Appeal Decision

Appeal Ref: APP/T2350/D/16/3150282

Blue Trees, Manor Road, Copster Green, Lancashire BB1 9EP

- The appeal is made under section 78 of the Town and Country Planning Act 1990 against a refusal to grant planning permission.
 - The appeal is made by Mr J Rowley against the decision of Ribble Valley Borough Council.
 - The application Ref 3/2016/0114, dated 29 January 2016, was refused by notice dated 15 March 2016.
 - The development proposed is erection of garage and boundary fence.
-

Side (North) Elevation

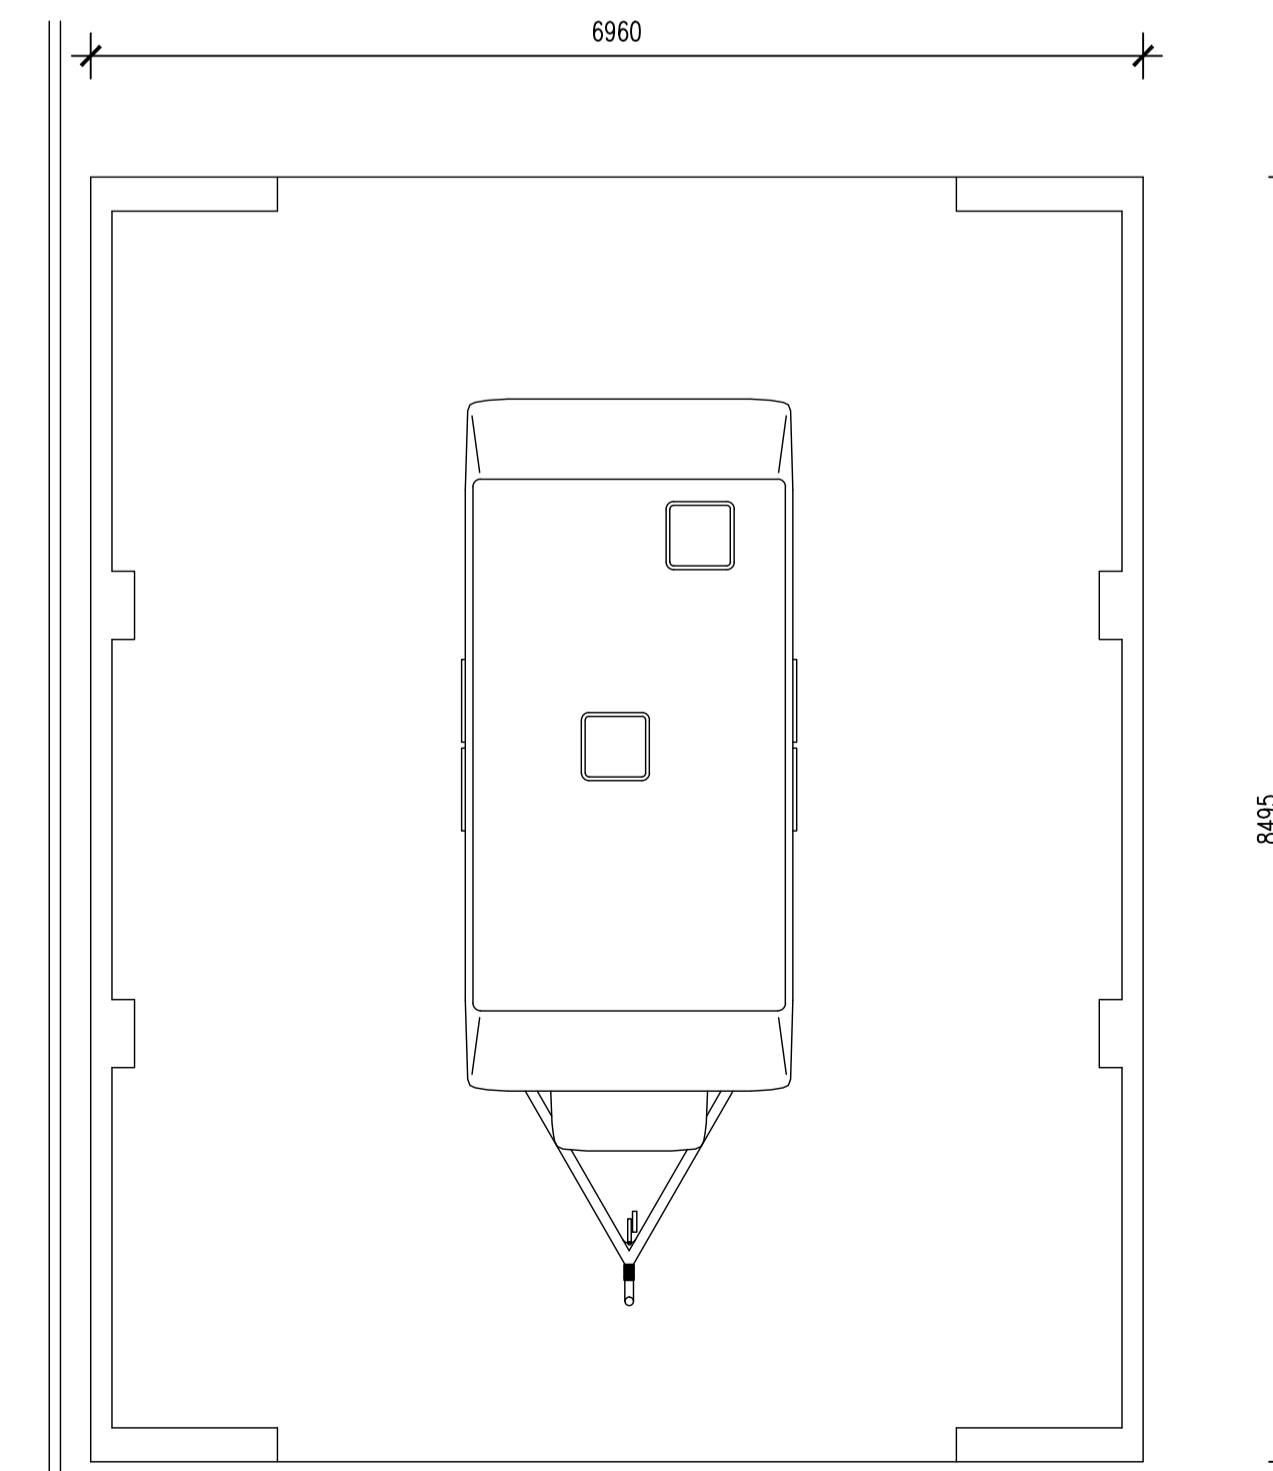
3. The proposed garage would be large and the appellant states that it is required for a caravan / motorhome. It would have large aluminium doors to the front and rear. Whilst it would be set back some distance from the road, it would still be visible especially due to its height. The submitted drawings show dimensions for the building as being 4.2 metres to the eaves and almost 5.9 metres to the ridge. The overall scale of this garage would appear at odds in this location, it would not reflect the semi-rural residential character of Copster Green but would appear incongruous to the area.

4. The fence would run along the boundary with the adjacent dwelling, Oaksmead and for most of its length it would be just under 3.2 metres high. Although it would be lower in height as it neared the road, given the long length and height it would be visually intrusive and out of keeping with the character of the area.
-

6. Although there is a tall hedge along the boundary with Oaksmead the garage would be very close to the boundary. Notwithstanding the hedge, which could easily be reduced in height or removed, given the height and proximity of the garage it would be visually intrusive when viewed from Oaksmead. Likewise the long stretch of fencing proposed along the boundary would be visually intrusive and result in an overbearing impact. However, due the orientation of Oaksmead in relation to the garage and fence, the proposal would not lead to direct overshadowing but this does not lessen the unacceptable impact of the proposal on the living conditions of the occupiers of Oaksmead.
